**CITY OF ALBUQUERQUE
PLANNING DEPARTMENT
August 26, 2015
DRB Comments**

PROJECT # 1010549

APPLICATION # 15-70289

RE: Lot 7, Block C, Interstate Industrial Park Unit 1

# Sketch Plat for Lots 7A and 7B, Block C Interstate Industrial Park Unit 1

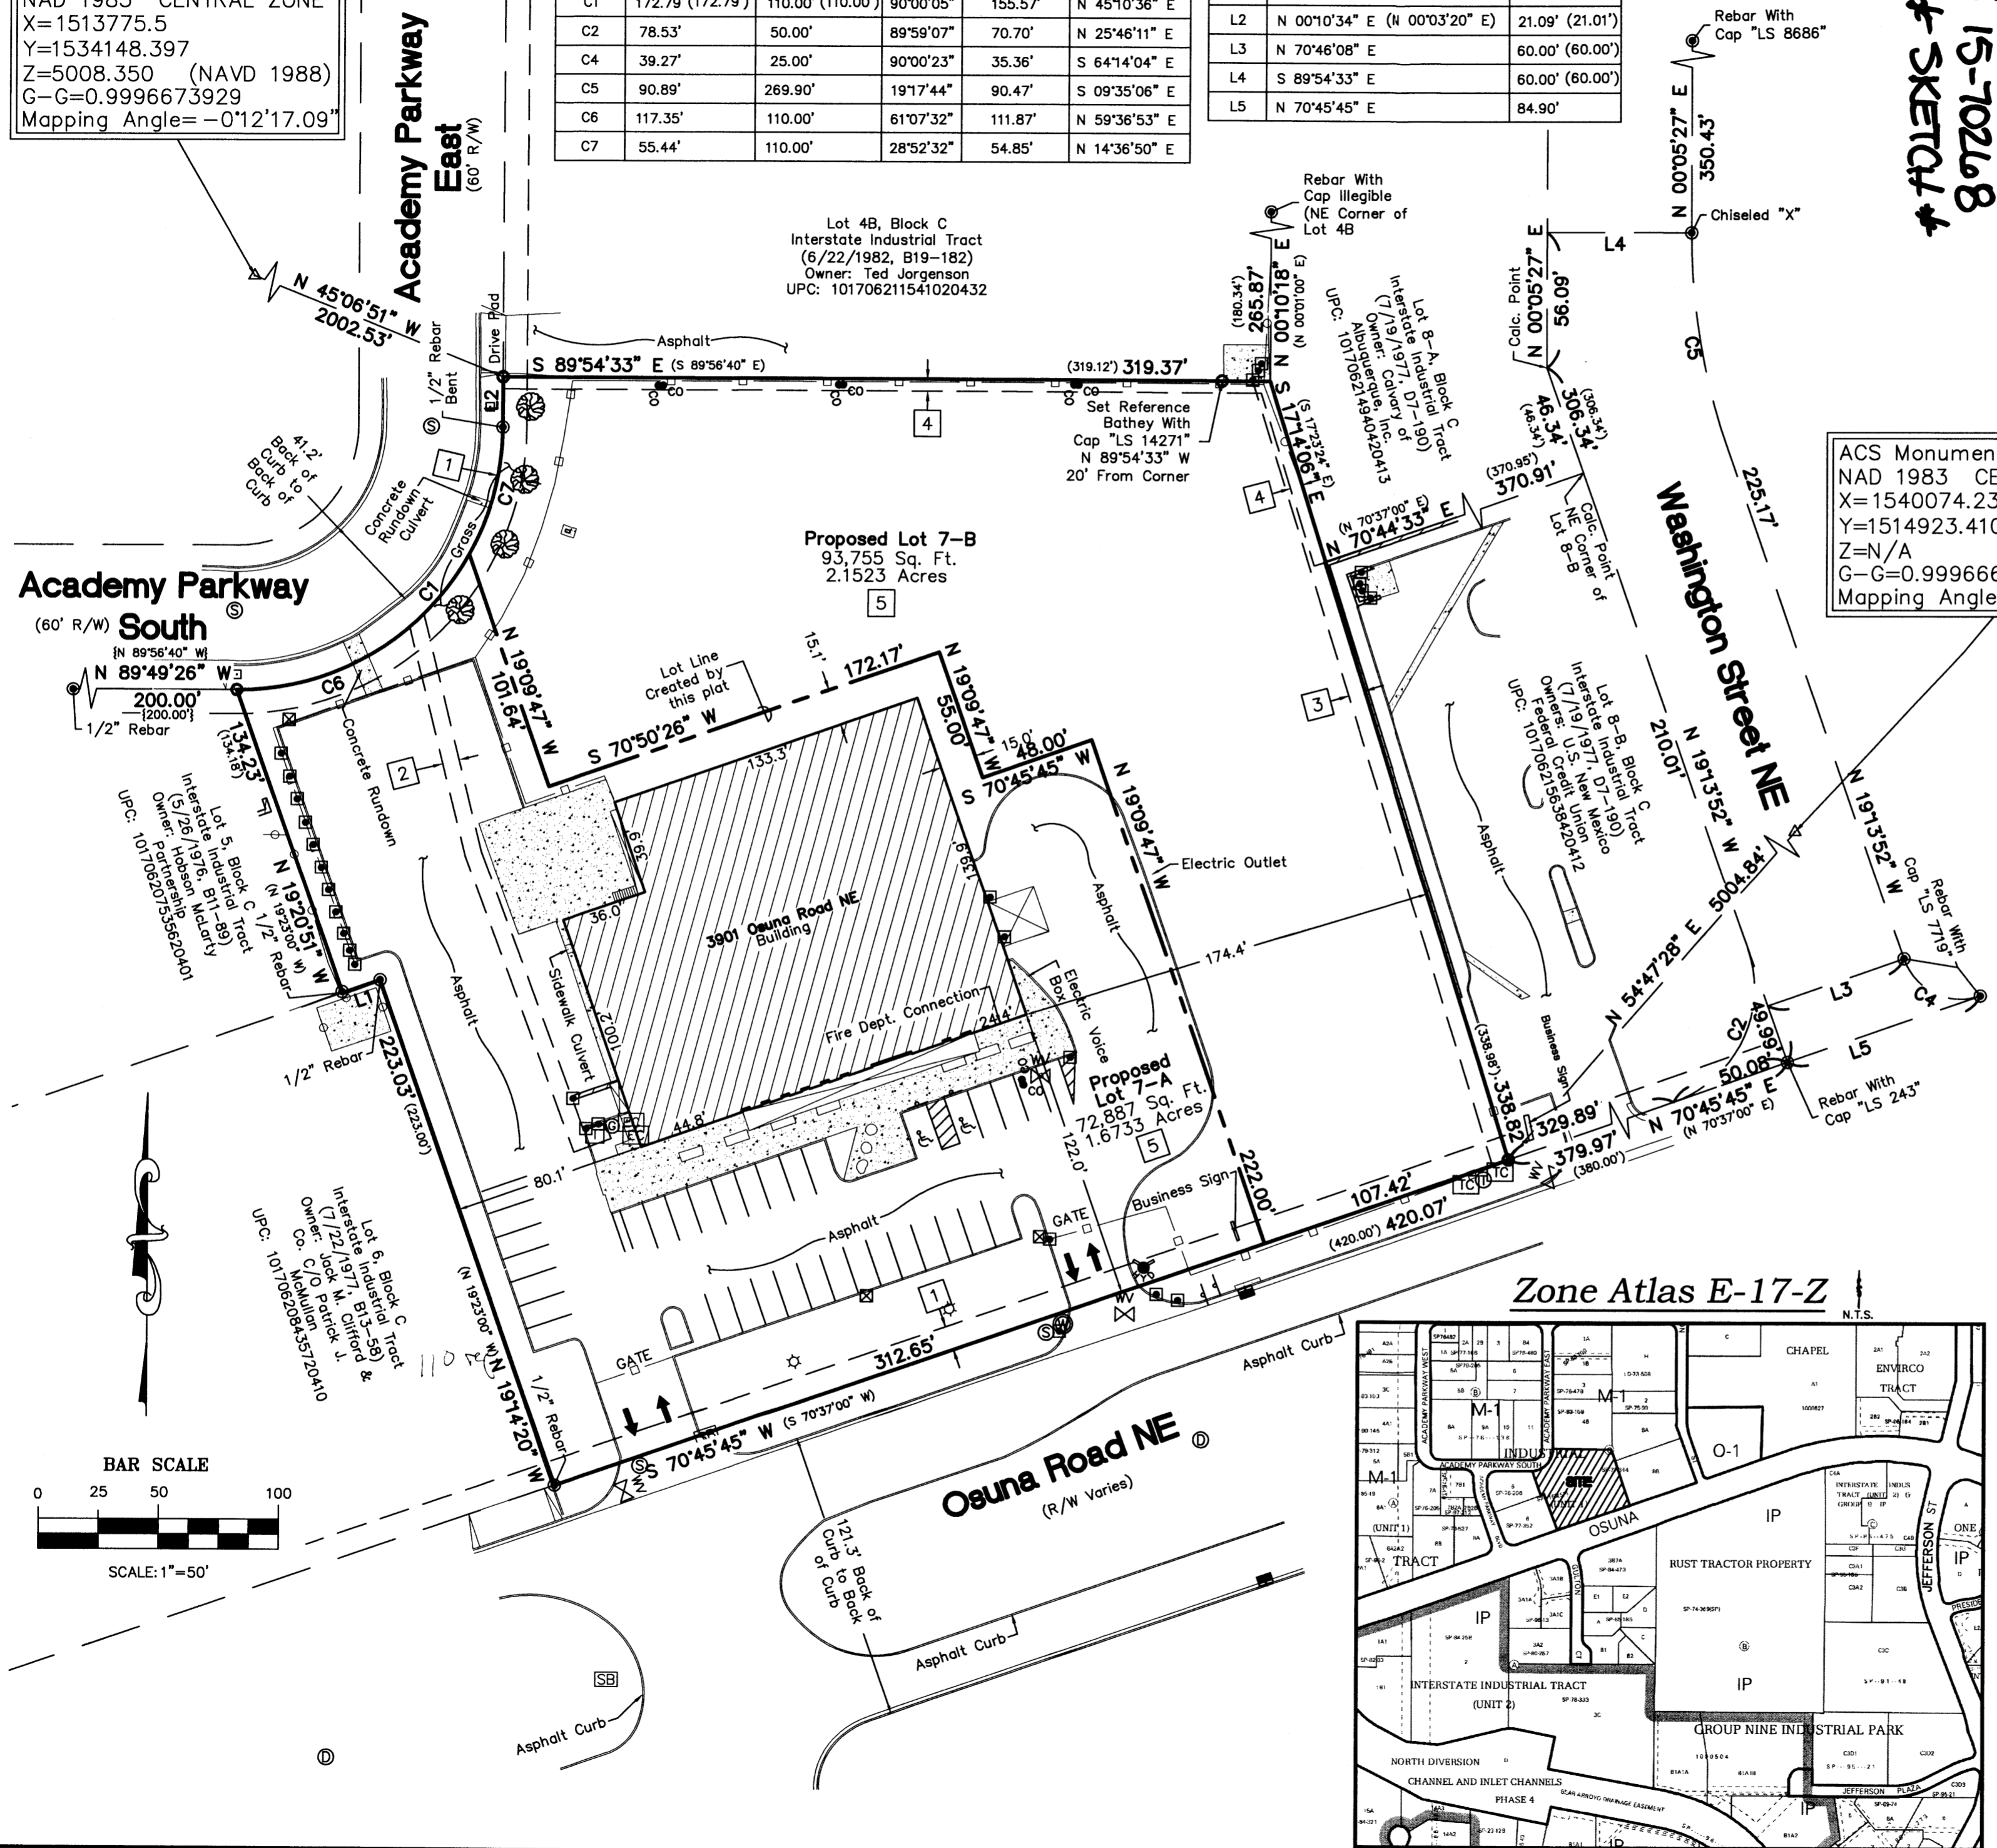
Parking calculations are needed to demonstrate the existing building meets minimum parking requirements on its new lot.

Parking calculations are needed to demonstrate the existing building meets minimum parking requirements on its new lot.

Based on the site plan, it does not appear the proposed building will meet minimum parking requirements on its new lot – if excess parking is available on adjacent lot (8-B) to the east, this portion of Lot 7 should be combined with Lot 8-B in one platting action.
